From: Nick Howard
Sent: 23 December 2011 14:43
To: Planningecons
Subject: RE: Planning Consultation on: BR/294/11/

APPLICATION BR/294/11/

Registered: 24-NOV-11
Site Address: 6-8 London Road Bognor Regis PO21 1PY
Grid Reference: 493594 99134
Category: Plan Applicat'n
Description of Works: Internal alterations and change of use from A1 (shop) to A3 (coffee shop) with ancillary A1 to form coffee shop on two floors.

PROPOSED GROUND FLOOR PLAN

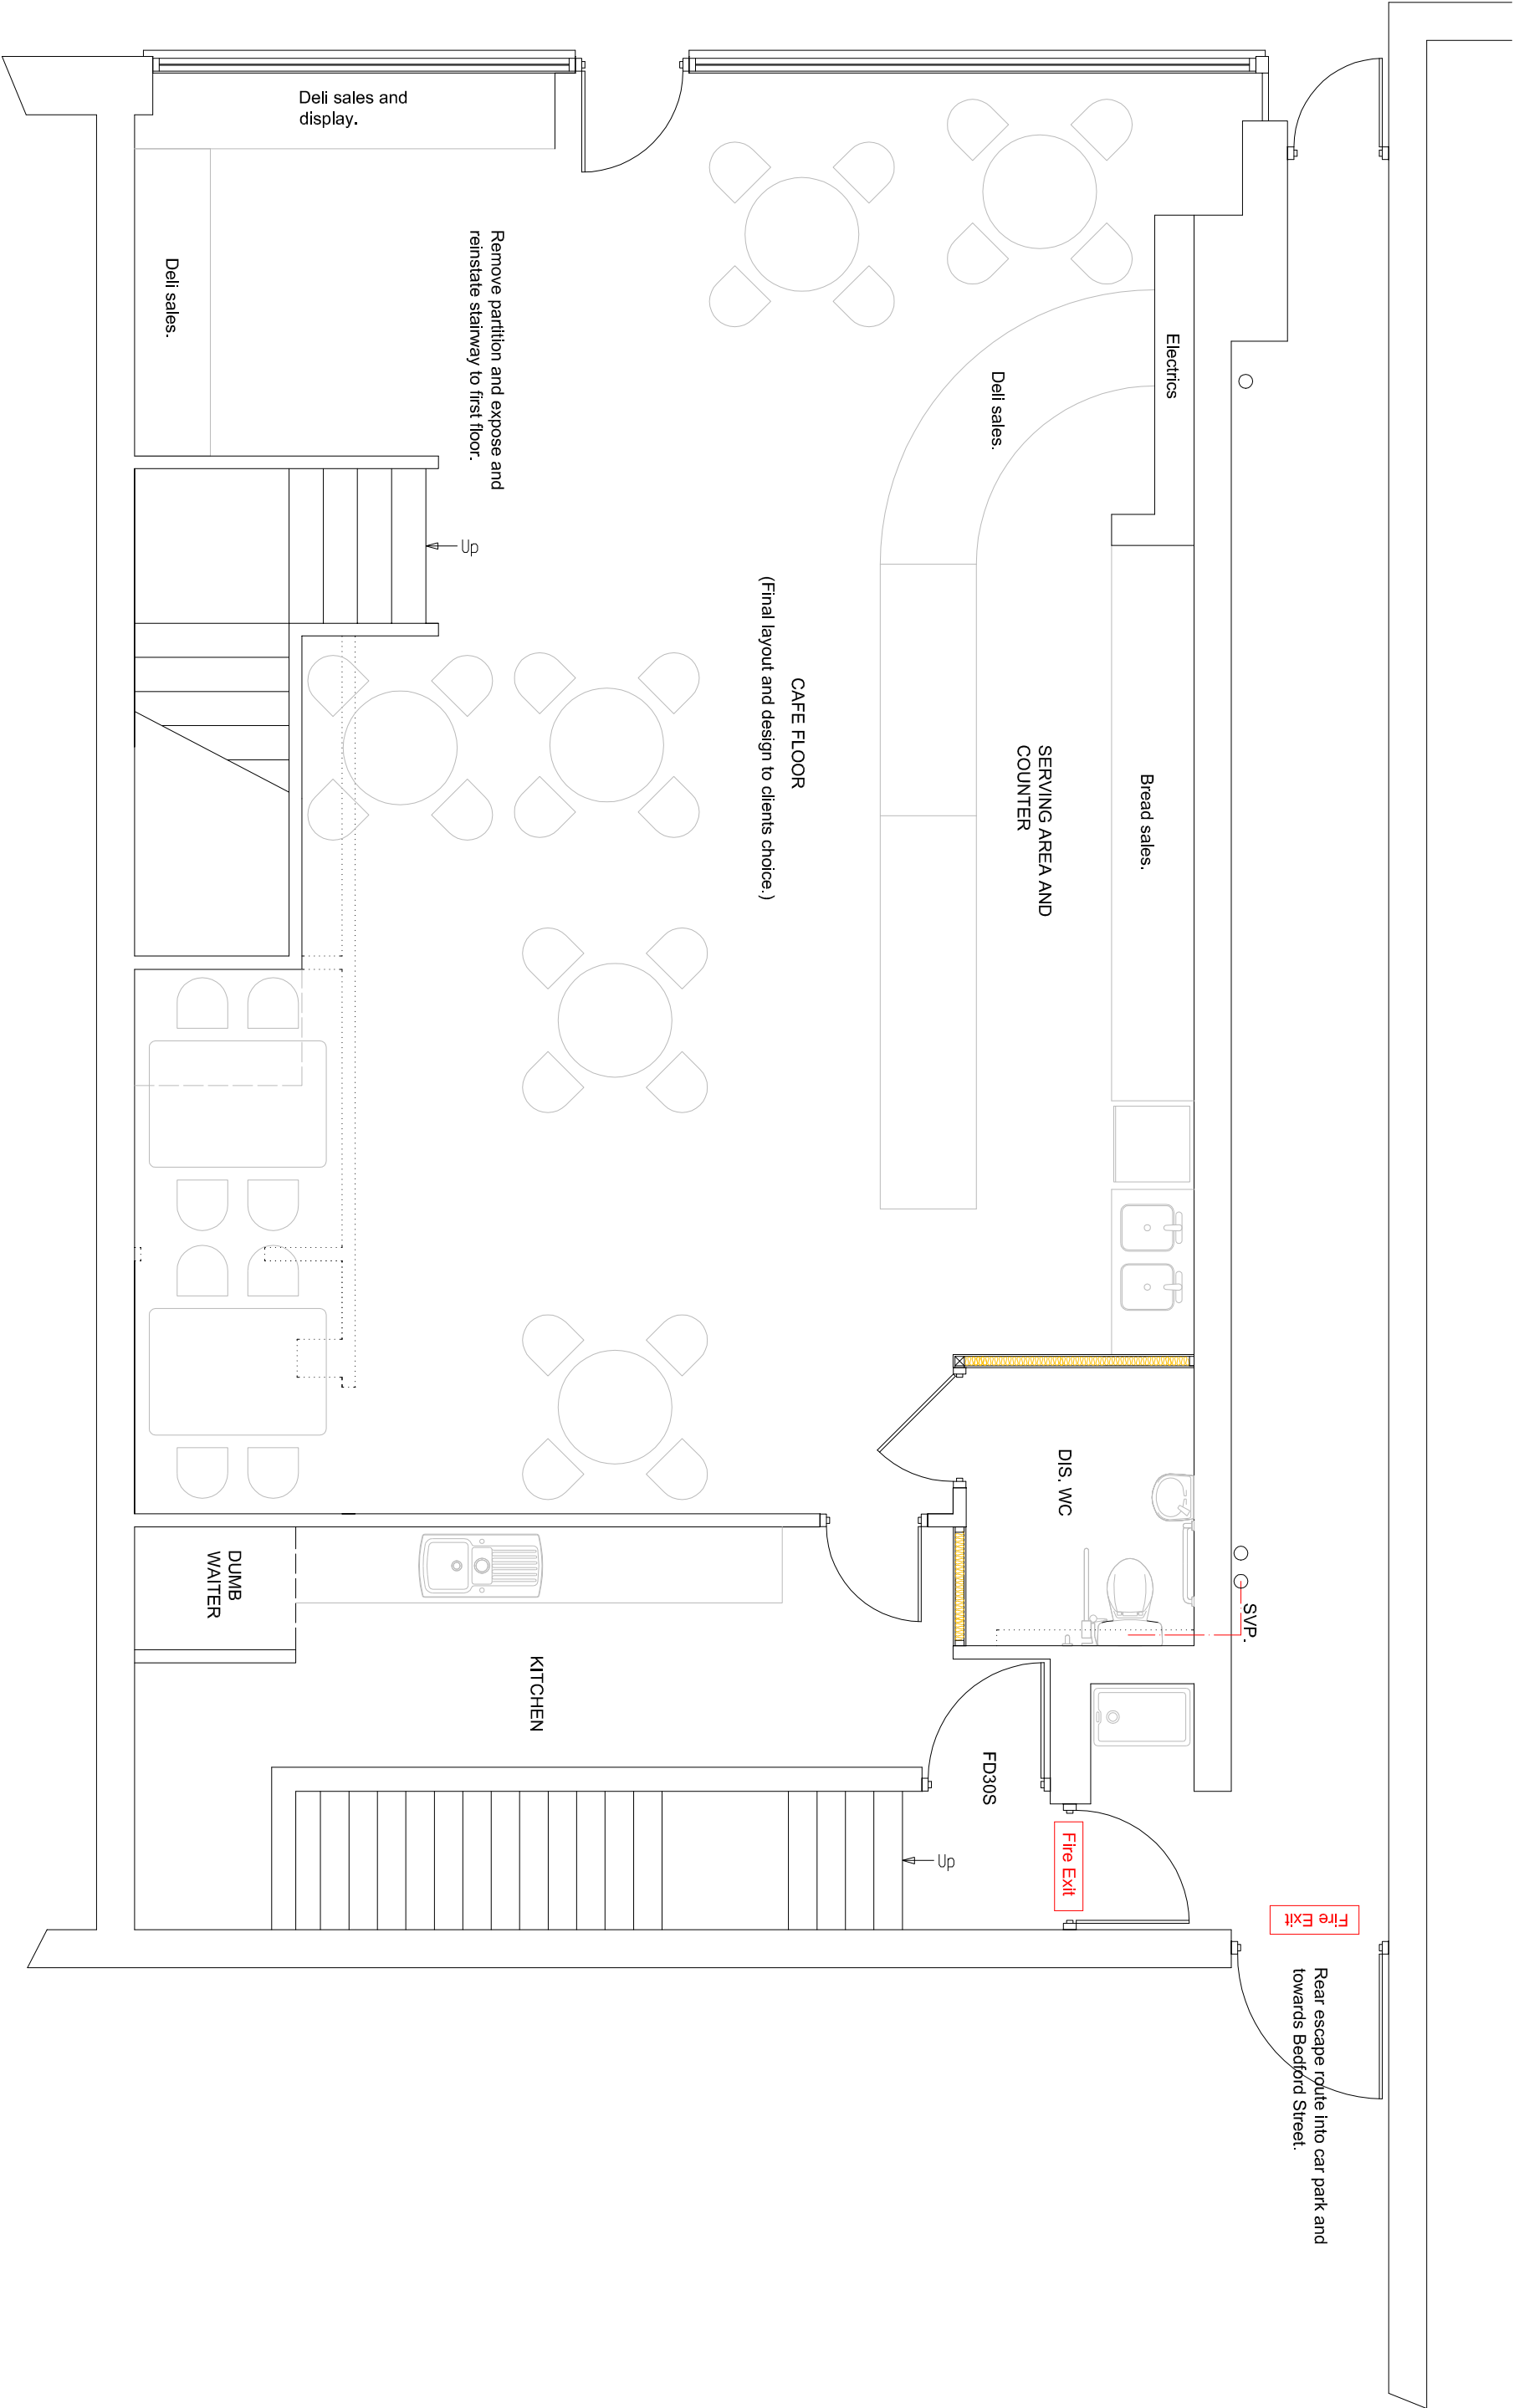
I noted on the plans that the disabled toilet is very close to the servery area and the kitchen door with no intervening lobby. I would consider relocation of the toilet as this area is a potential busy traffic area for customers and staff particularly from the kitchen and from customers queuing for the disabled toilet. It also opens out into an area where food is handled. In addition I did not see on the plans where the food is going to be stored because with the original plans there was a large storage room on the first floor. I am happy to discuss the toilet provision standards.
